From: [Alan and Pamela Walton](#)
To: [Murphy, Alexander N: a303sparkfordtoilchester@pins.gsi.gov.uk](#)
Subject: Re: 8.18 Mr and Mrs Alan Walton SoCG - TR010036 Long Hazel Park Reference 20014098
Date: 07 June 2019 13:22:43

Noise Modelling Methodology

General Proposed Hazlegrove Junction Layout

Drawing Title
**FIGURE 11.5
NOISE LEVELS IN THE DO SOMETHING OPENING
YEAR LA10, 18HR [dB] - SHEET 1 OF 4**

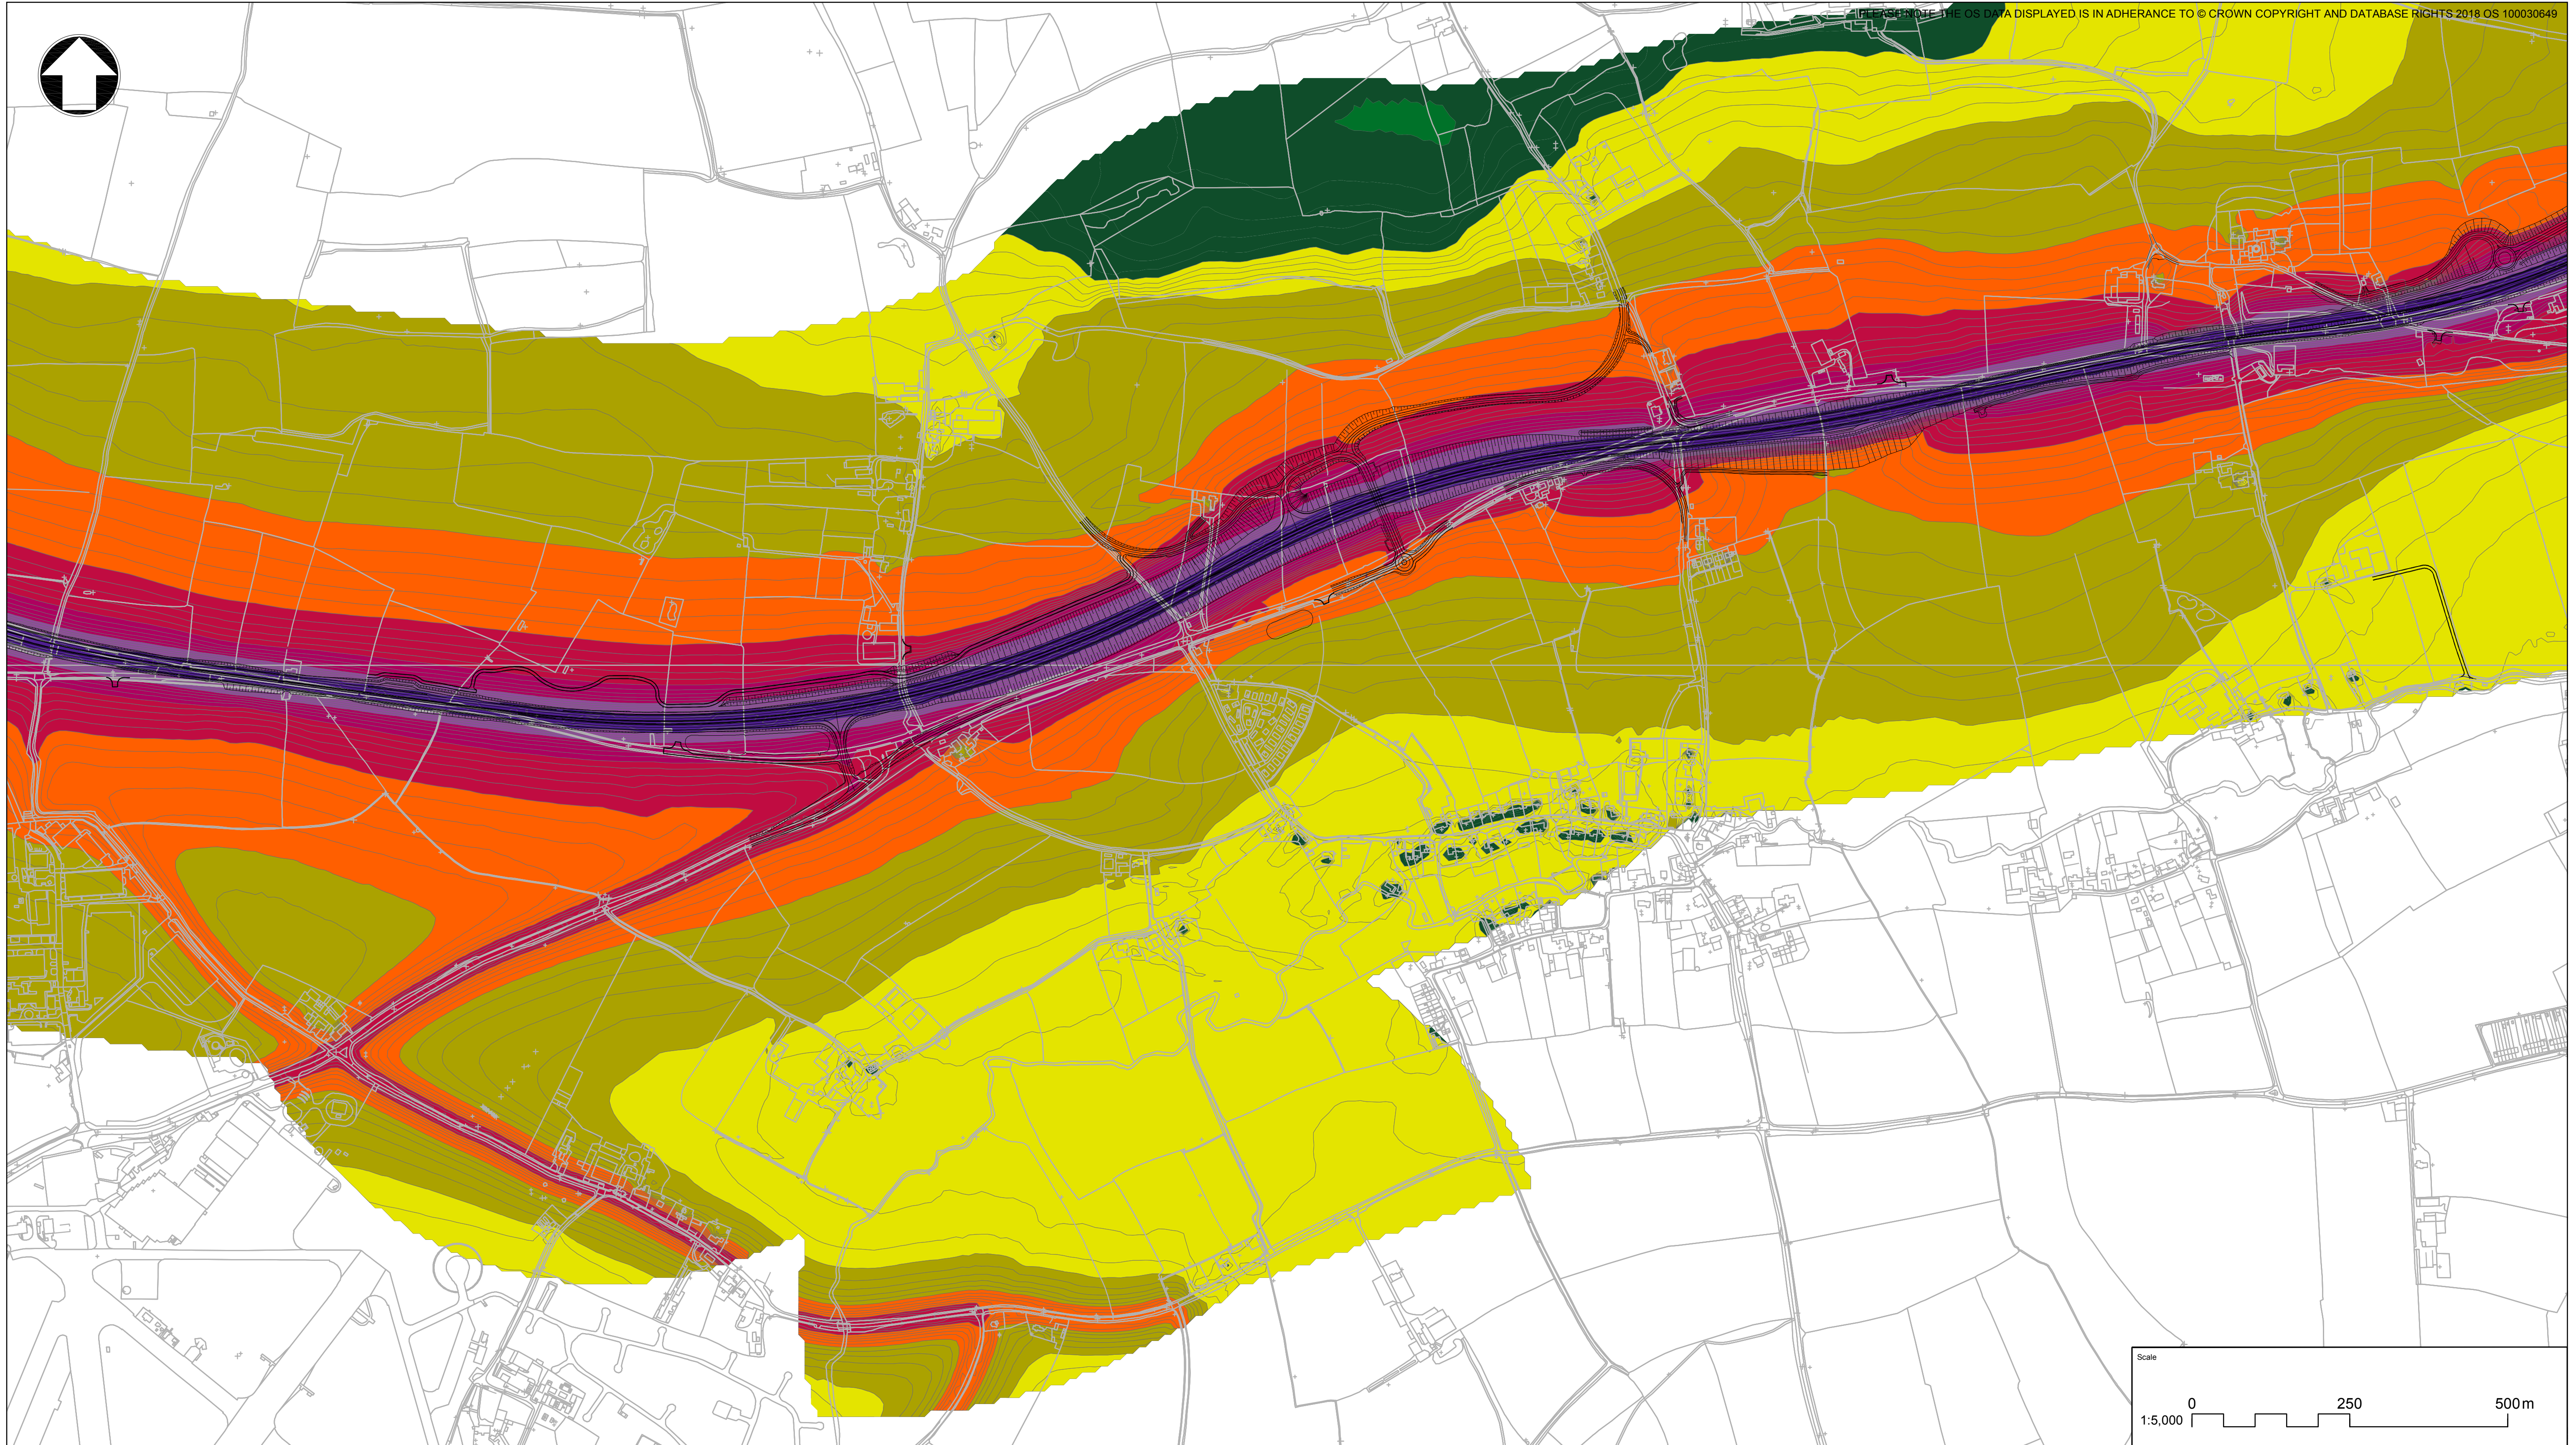
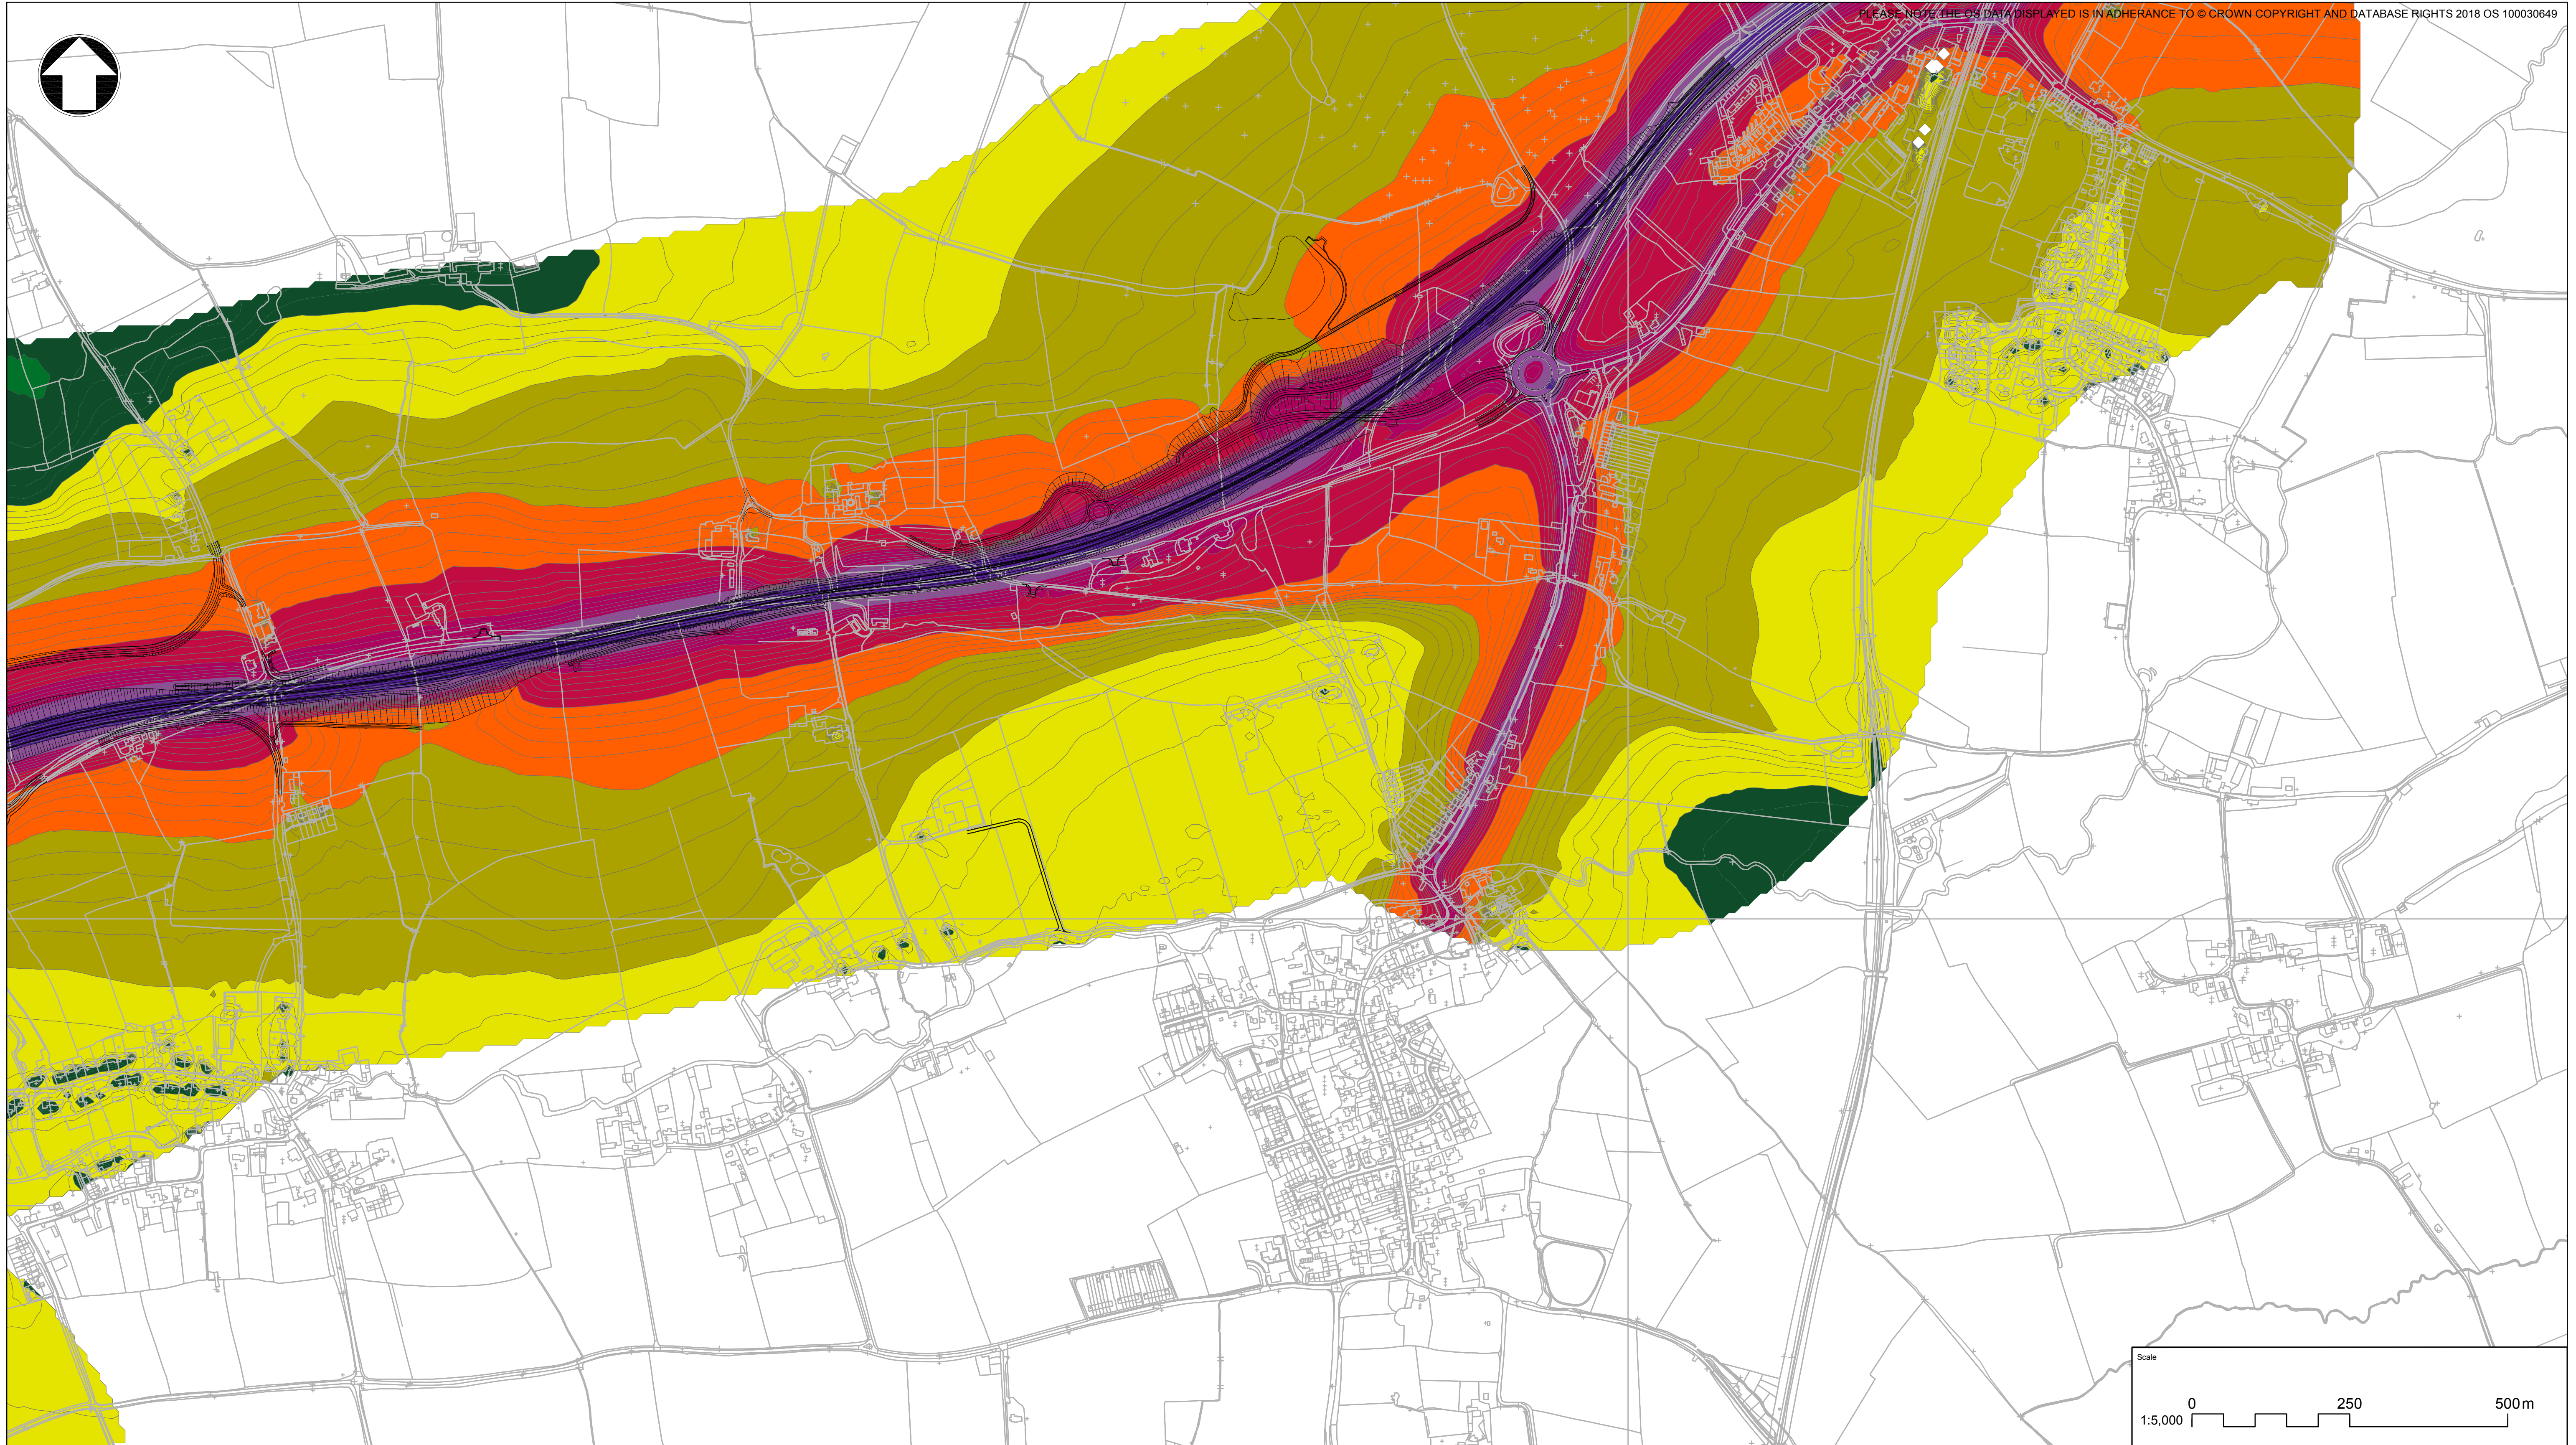
Long Hazel Park is downwind and is in line from the proposed elevated section of the dual carriageway. Noise barriers on either side of the carriageway will do little to mitigate the noise as the wind blows the increased noise in to Long Hazel Park and the surrounding area of the village. This section of road will be four lanes with a 70 mph speed limit. Currently it is two lanes with a 50 mph speed limit but as traffic merges on to the westbound carriageway the speed is often slower than 50 mph. The prevailing wind is from the west or southwest with speeds of up to 60 mph during weather storms especially in the winter when foliage has dropped from the trees. The Model does not take these factors into consideration.
